DFT PR-2024-010446

SI-2024-00774

RESPONSE TO: Code Enforcement Comments

PROJECT NUMBER: PR-2024-010446

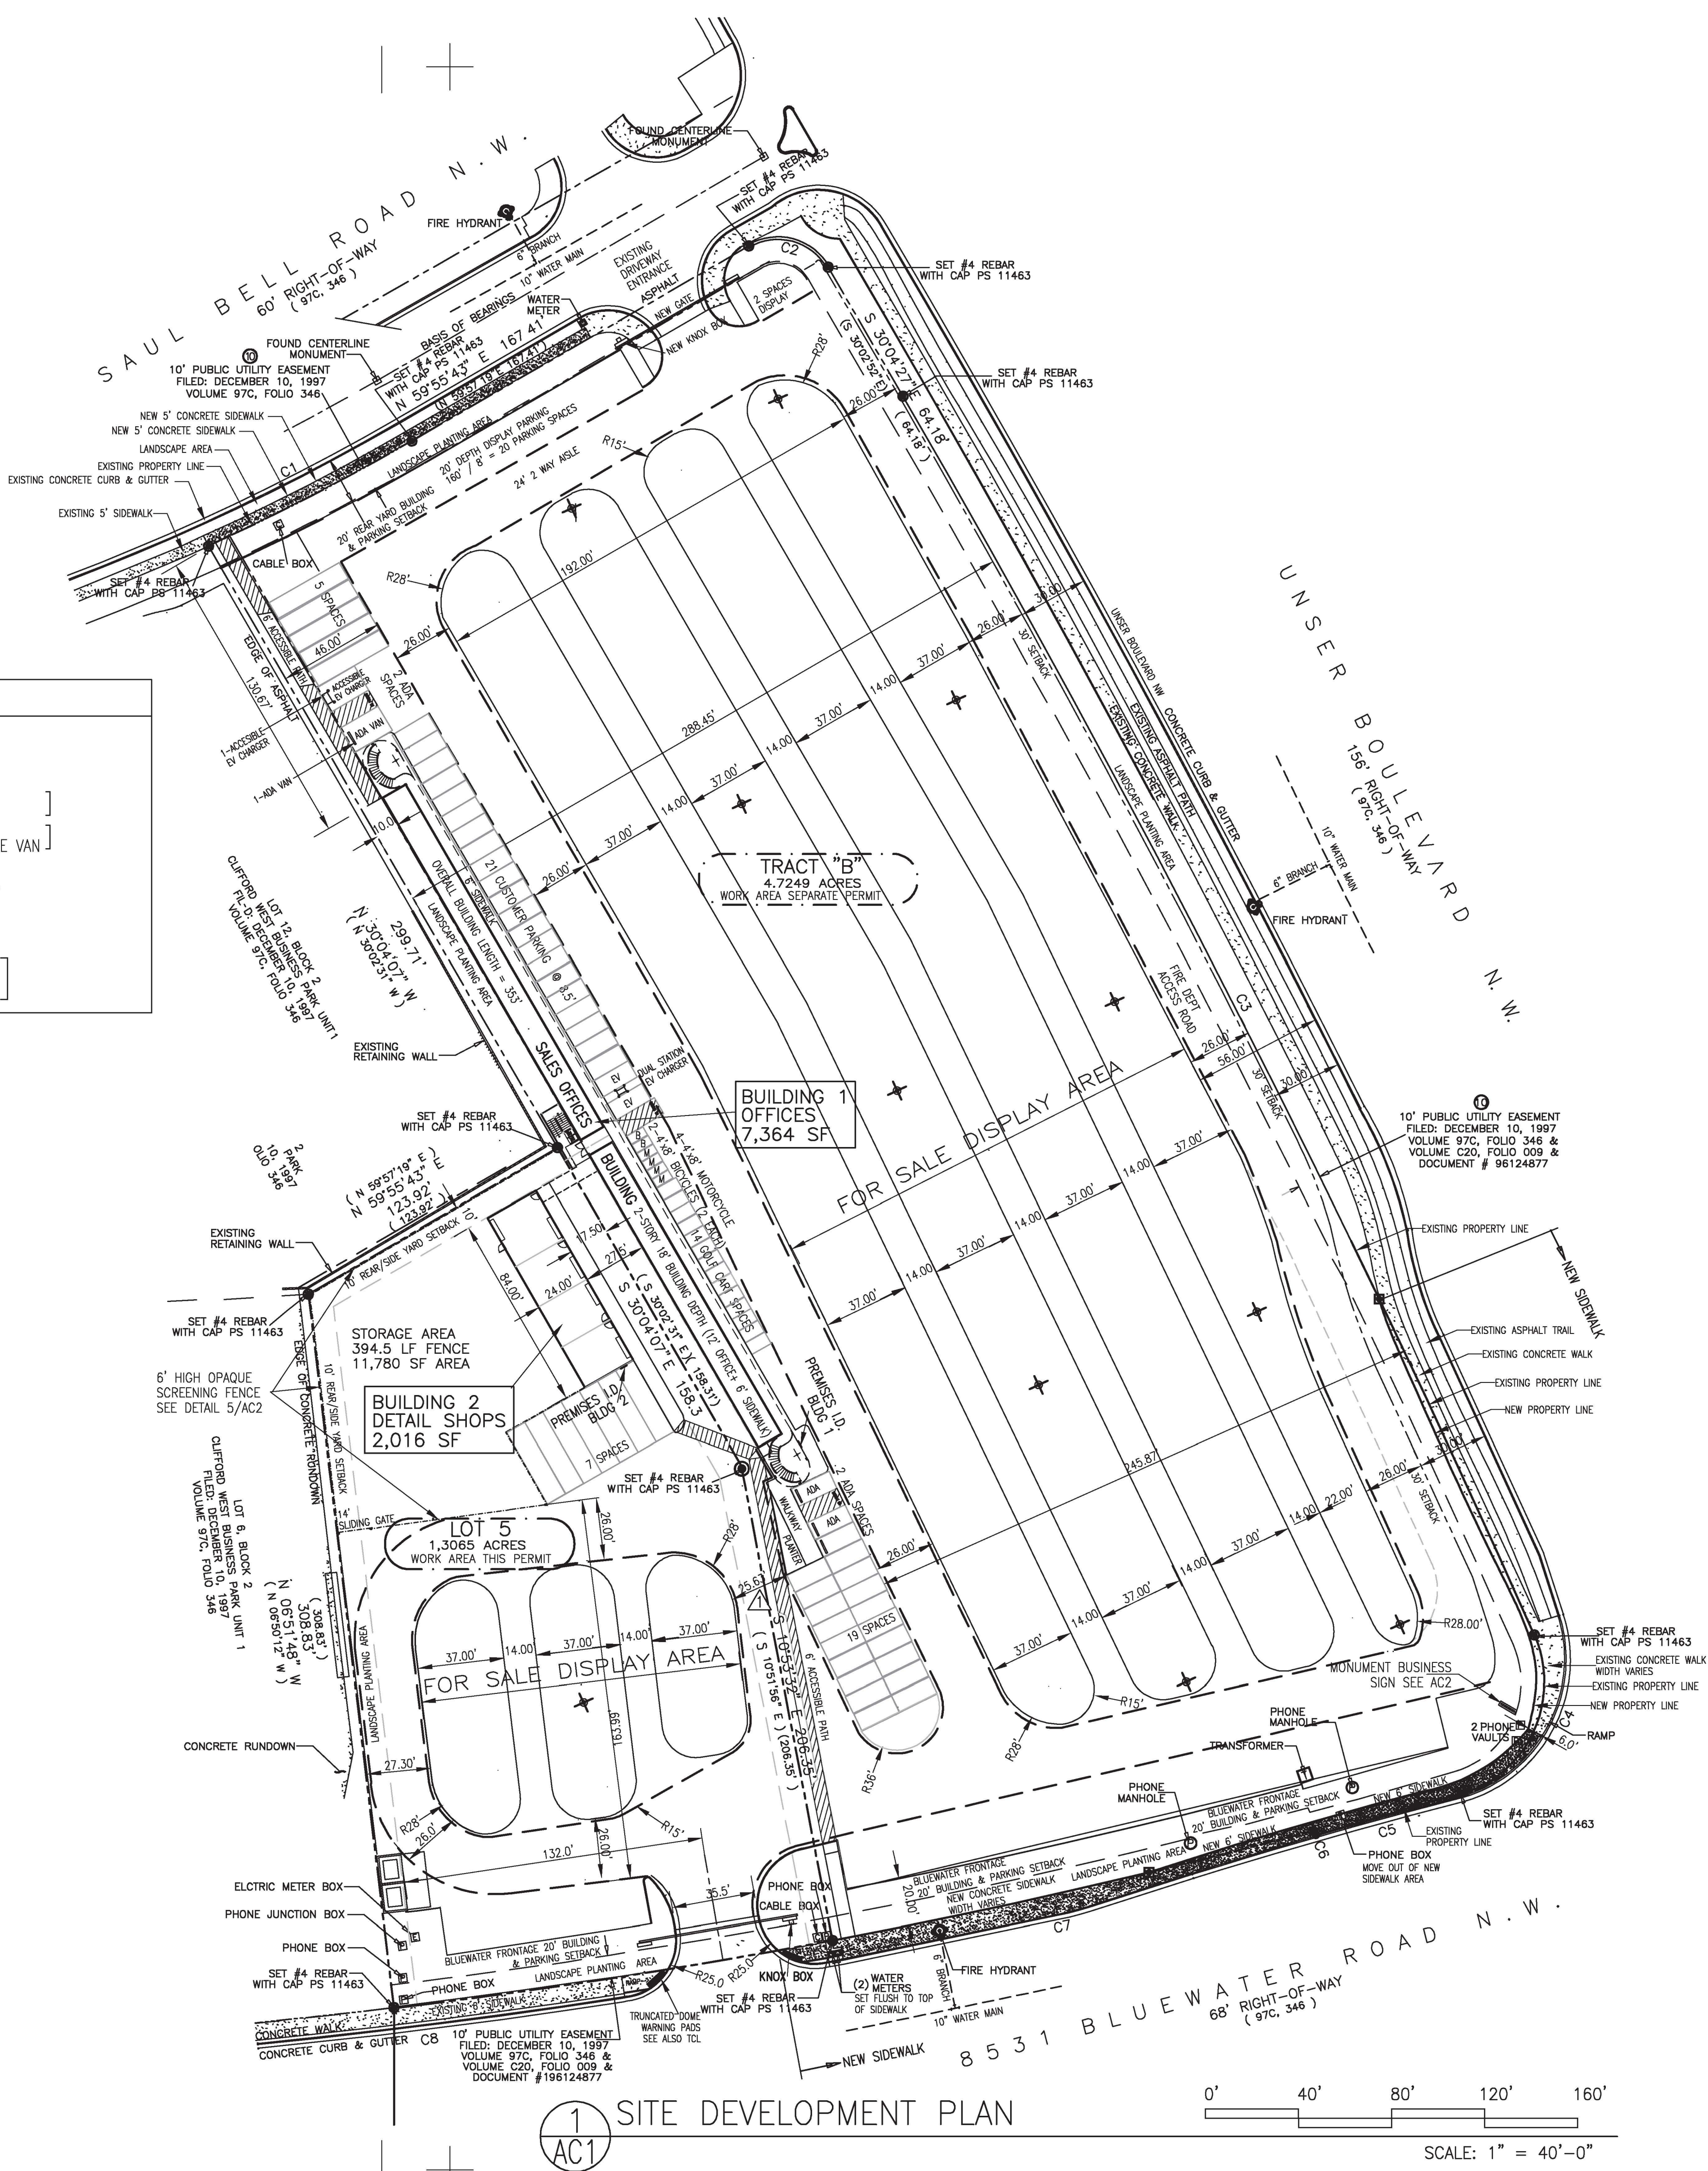
- **With a Bluewater address, the Site Plan, measurements, and Landscaping Plan will need to reflect that as the front lot line.**

The Site Plan needs to include measurements for setbacks.

The property address has been assigned as 8531 Bluewater Rd NW. This establishes the Front Line location on the south edge of Lot 5 and Tract B and is **reflected on Site Plan**

Building and improvements required setback distances are given in the *BUILDING SITE COVERAGE* section of the CWBP building regulations as tabulated below.

CWBP sets the measurement of setbacks to parking and buildings from the back of the street curb. The depth of the setback varies according to the classification of the street adjoining the property. Sites which front on more than one street must satisfy the Front Yard Setback for all such streets. The meaning of this requirement is that on corner lots the standard 10’ side or rear setback is not to be applied. For this project, all three street classifications are applicable. Setbacks are compliant as shown on the Site Plan Sheet AC1

CWBP Master Plan Setbacks	Building Front Yard	Parking Area
Principal Arterial	50 feet	30 feet
Collector Street	20 feet	20 feet
Local Street	15 feet	15 feet
Street Name and Classification	Building Setback	Parking Setback
Unser Blvd - Principle Arterial	50 feet	30 feet
Bluewater Rd – Collector Street	20 feet	20 feet
Saul Bell Rd – Local Street	15 feet	15 feet

Drawing file: 2-24-2025 / A1-OFFICE PLANS & ELEVS.pdf

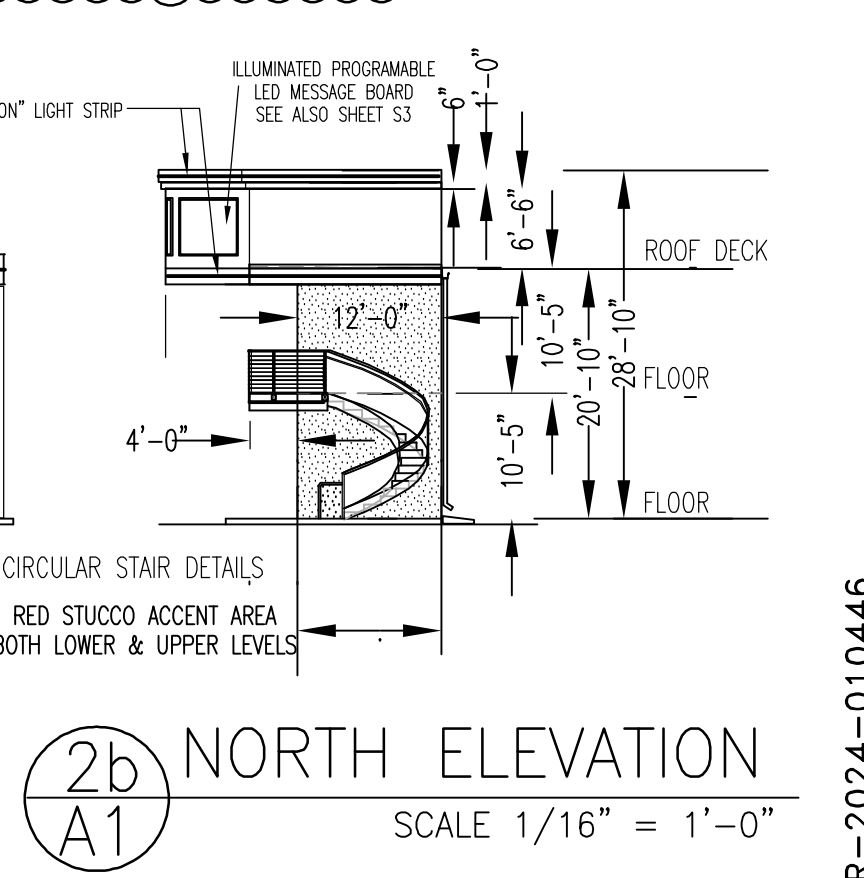
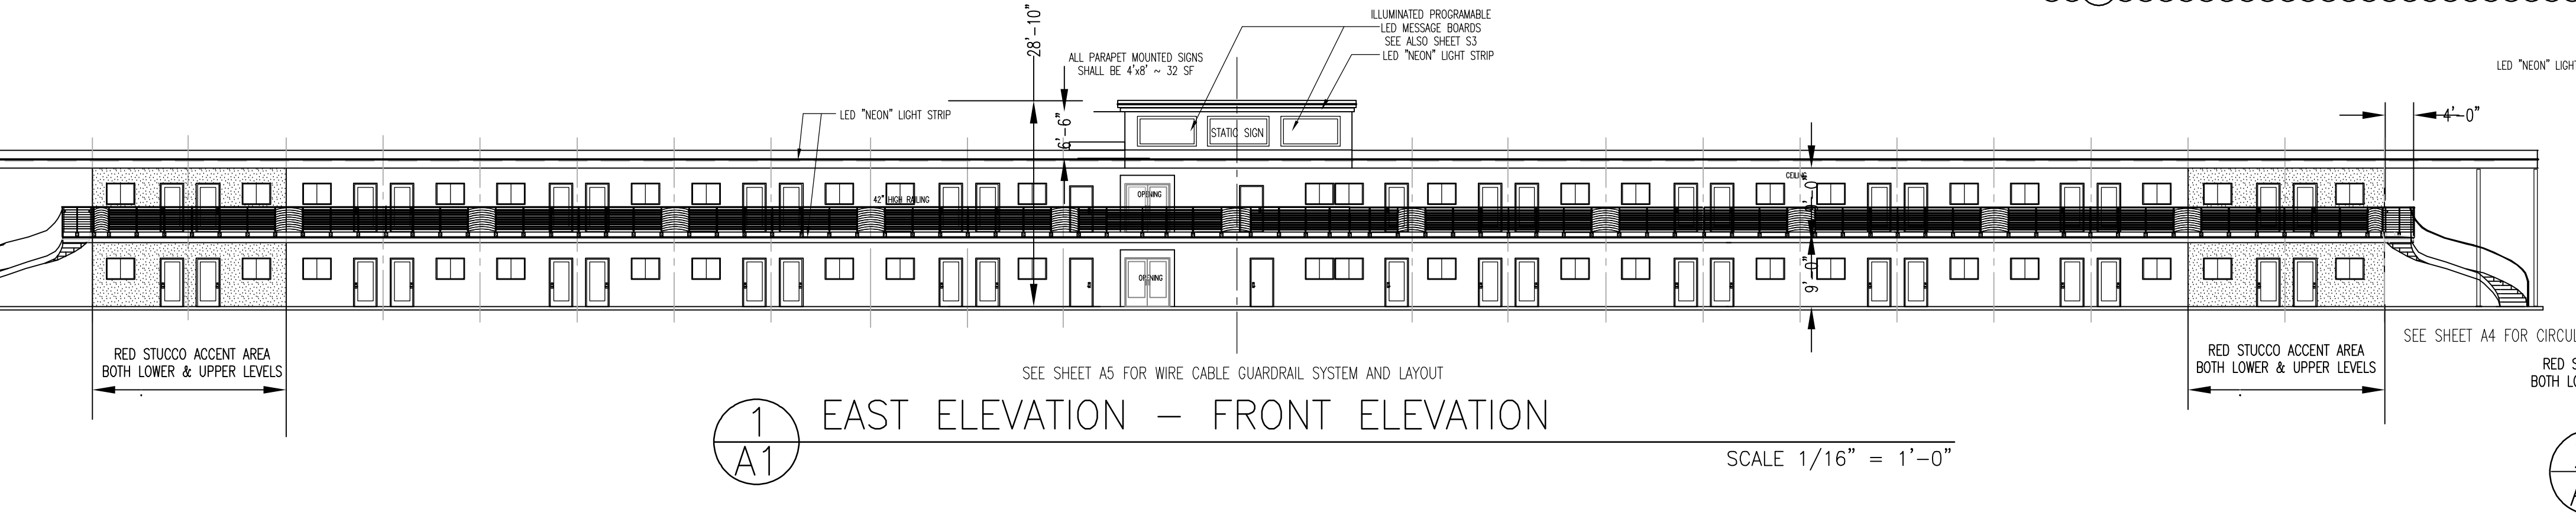
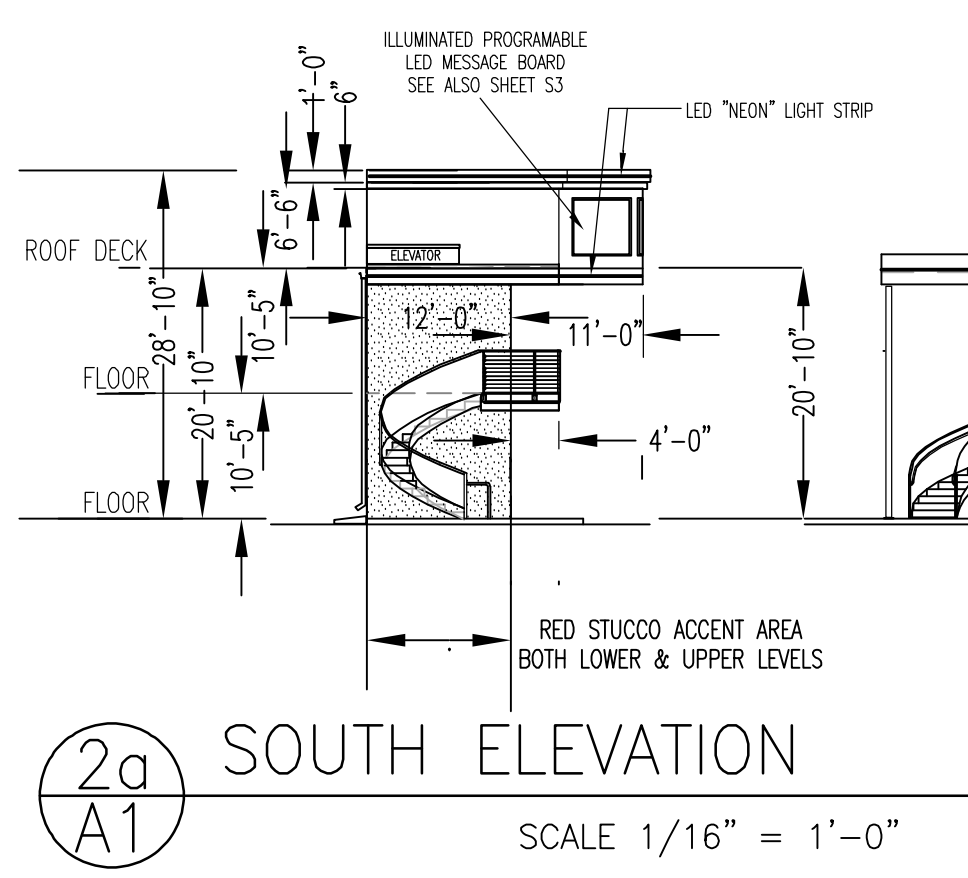
- **Elevation pages need to include measurements, dimensions, and information regarding screening. Provide detail to demonstrate and explain compliance with all sections within 5-11-E and 5-11-E-2.**

Include detail regarding how the façade and colors will meet the Clifford plan design requirements.

The CWMP Section *BUILDING REGULATIONS* details various means and measures to be employed in the façade design of buildings. These definitions and the IDO requirements are similar enough that one reflects the other. Both the CWMP and the IDO concerns are addressed as described below. The Building Elevations are shown on Sheet A1 Office Building and Sheet A6 Shops Secondary Building.

- 1. These buildings are very much to human scale with a maximum height of two stories in the primary Office Building and single story in the secondary Shop Building.
- 2. Street facing facades provide the two required features via:
 - b. Windows on upper floors;
 - c. Primary pedestrian entrances;
 - d. Overhang of roof edges and balcony walkway weather protection
- 3. Street facing facades over 100' in length provide one required feature:
 - d. Three-dimensional roof overhang cornice;
 - e. Change in parapet height above the main entrance.
- 4. The Shop Accessory building follows the motif of the primary building with its extended roof overhangs, and the wall and detail color patterns.

Existing Building Elevation drawings have been revised with additional information as requested. The finish materials and colors are specified for primary and secondary surfaces as per CWBP Master Plan: “Building design and construction shall be used to create a structure with attractive fronts of quality materials. The quality materials must be applied to exterior walls on the front of the building and to the sides of the building up to 100' from any public street curb.”

A reading of the CWBP Building Regulations certainly conveys a desire that this development shall not become a collection of nondescript industrial metal buildings with rectangular floor plans and uninterrupted metal sided walls. In its stead, both projected buildings are surfaced with a stucco wall finish listed as a quality material in the Clifford West Building Regulations.

Using a mid-century iconic building style as the signature image of a multi-dealer vehicle sales center certainly raises this development from routine to one of a kind. The unique main image background is of a 60's roadside diner with an extended canopy roof over an international style. The low-slung horizontal building is a particularly appropriate format for the Office Building which provides a large number of small offices each exposed to a view over the vehicle Display Areas. With each office having unencumbered access to the public, the independent dealers can more easily be located by the customer. Likewise, the company offices, elevator and public restrooms are grouped in the central core area for additional ease of access. The marquee roof addition on the central core provides a readily understood break in the roof line and a focal point for the entire building facade.

3 PERIMETER WIRE FENCING

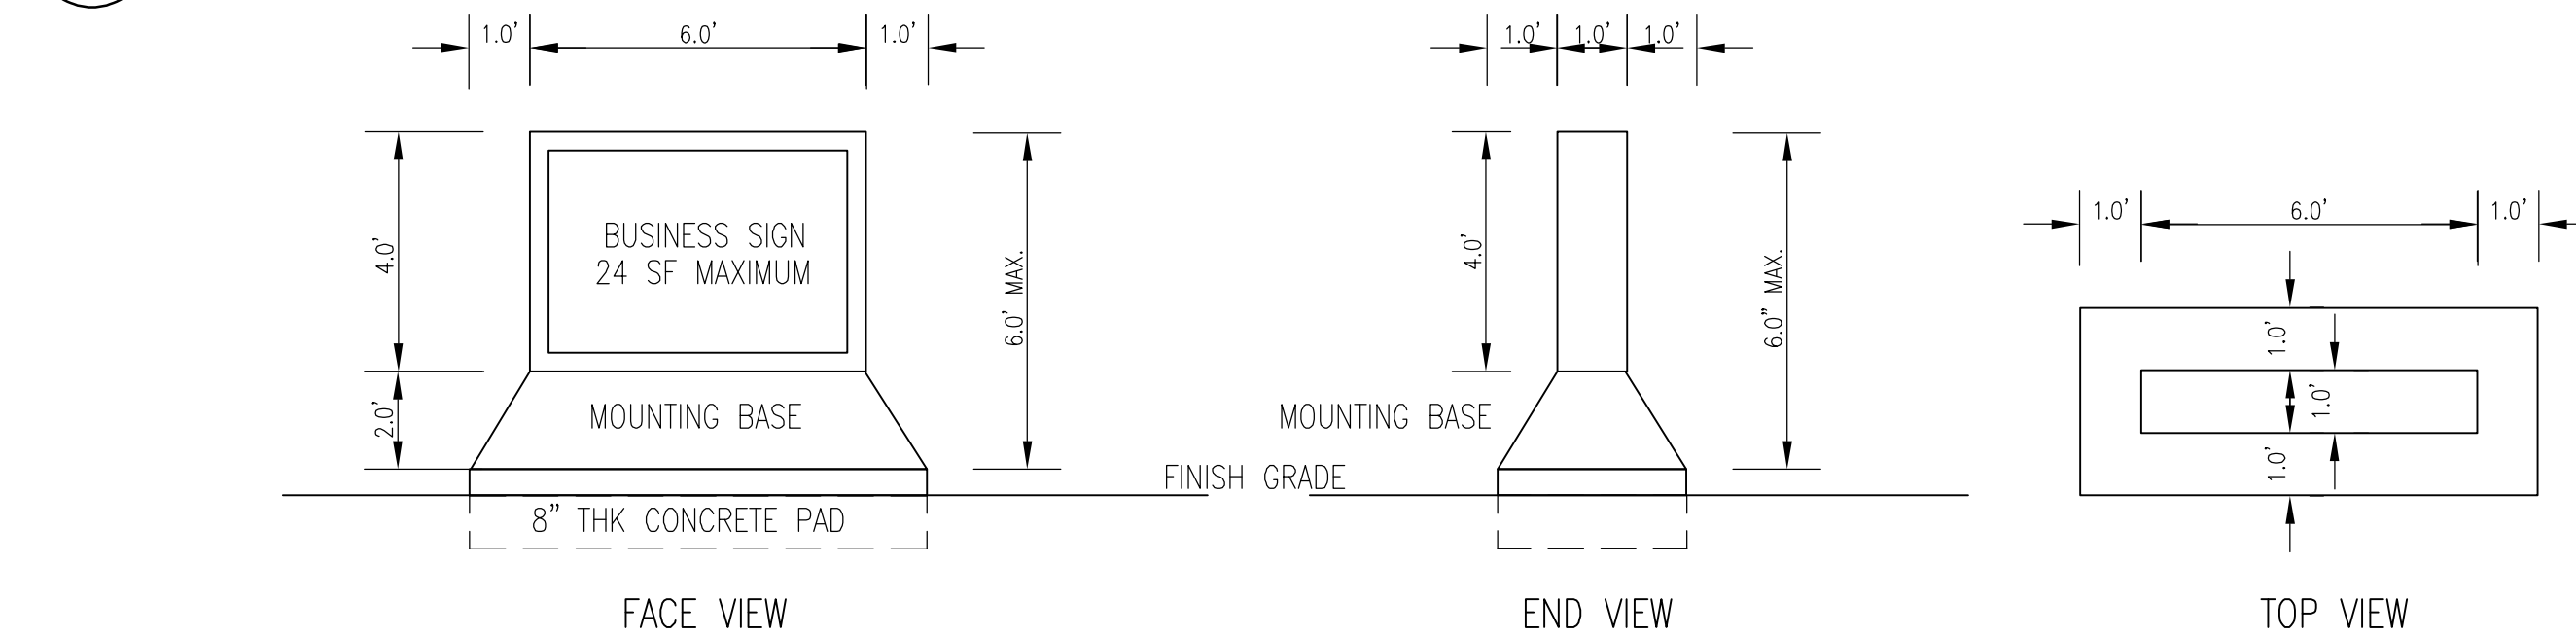
- **Confirm with Code Enforcement that the proposed metal fencing is meeting the material requirements of the Clifford West Plan and/or IDO standards.**

The CWBP does not provide any discussion of fence materials or design. The 6’ high, 3 crimp wire fencing specified for this project is the same as that which the City has commonly used for perimeter fencing of playgrounds and other public activity areas. Separate fencing permit has been applied for (GP-2024-16832).
